Your ref:	I.Denticle 38 Queen Anne St	Please reply to:	Rayhan Ali
Our ref:	21/06799/FULL	Tel No:	07866033247
		Fee Queries:	0207 641 6500;
		Email:	planningreception@westminster.gov.uk;
Mr Alan Tate Grey Associates Flat 1 1 Dart Villas Totnes TQ9 5ET UK		Incomplete Applications Development Planning City of Westminster PO Box 732 Redhill, RH1 9FL	
		7 October 2021

Address: 38 Queen Anne Street, London, W1G 8HZ

Proposal: Use of the bulidng as a dental clinic and the installation of a plant services unit in rear courtyard. (linked with 21/06800/LBC)

DRAWING EXISTING & PROPOSED ELEVATIONS

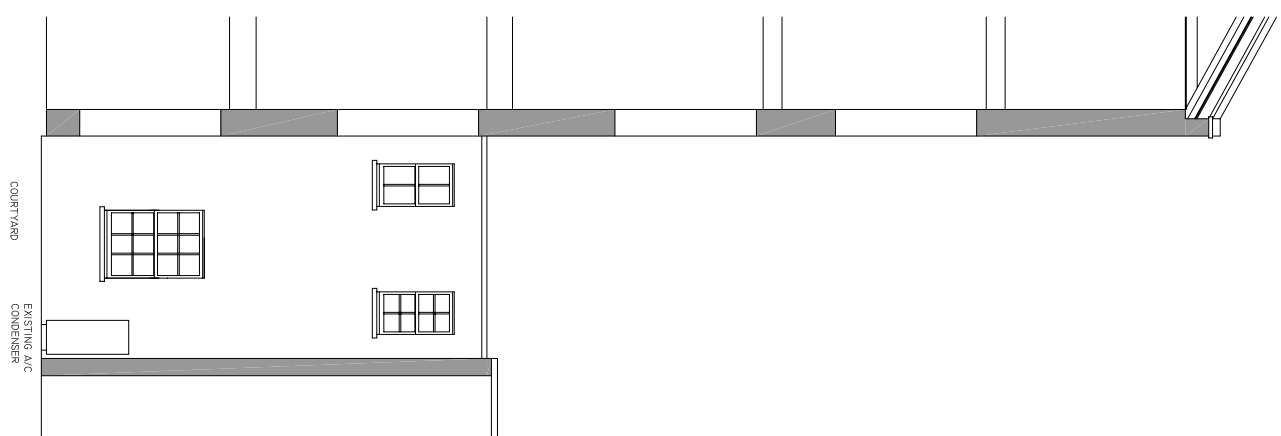
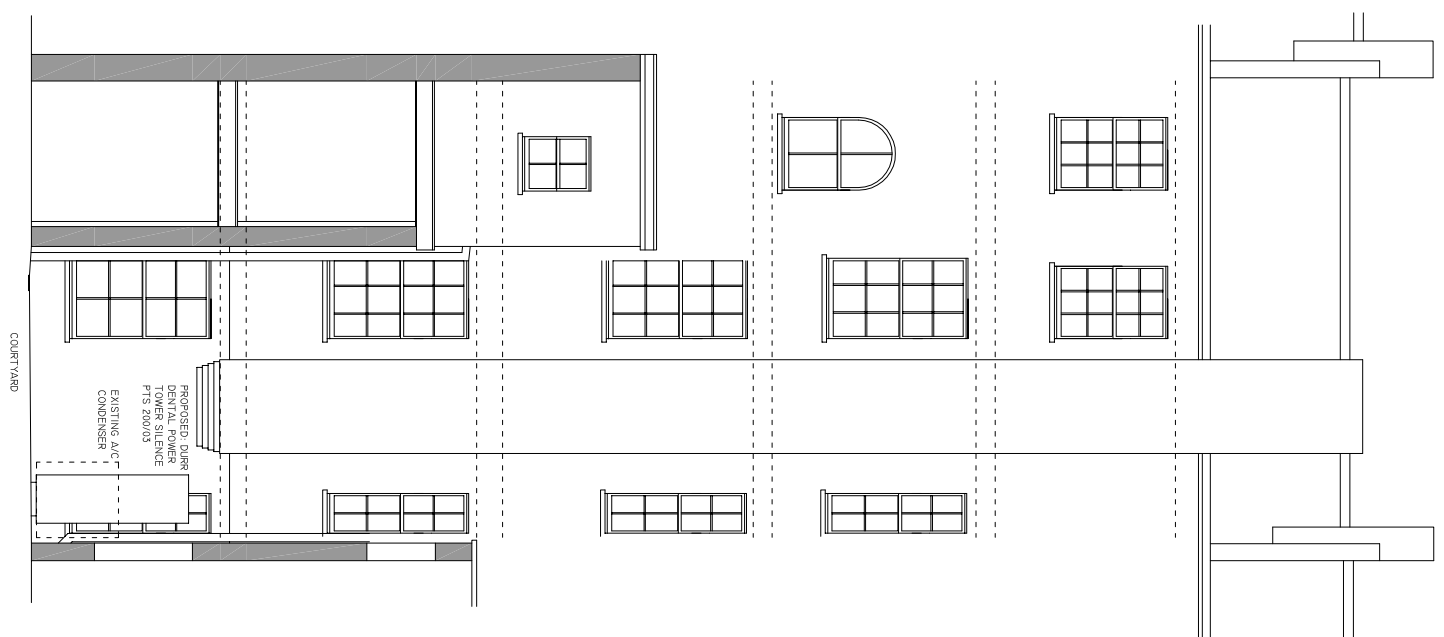
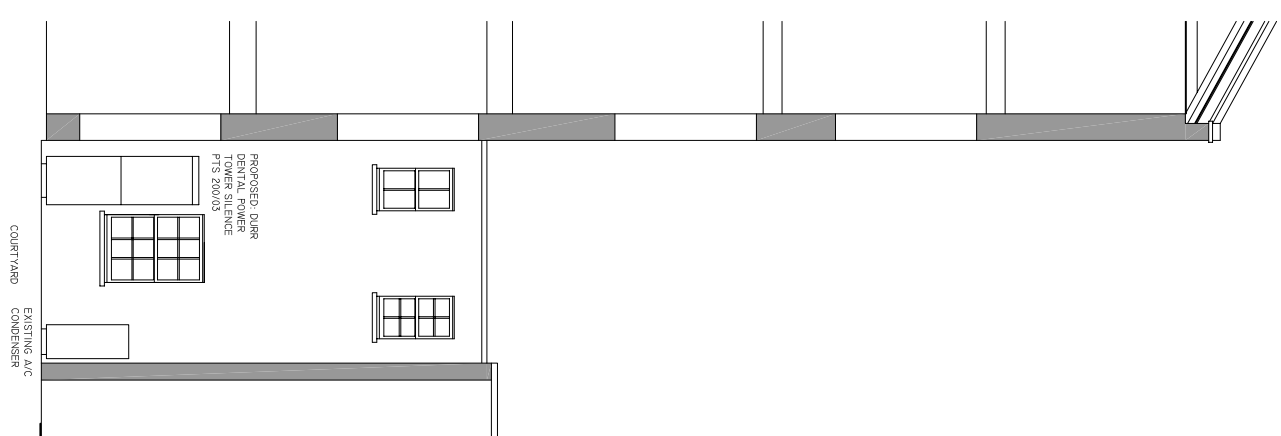
- proposed rear elevation sections
- existing and proposed elevations of the AC unit

2 Please provide manufacturers specifications including technical data, size and colour of the proposed plant equipment.
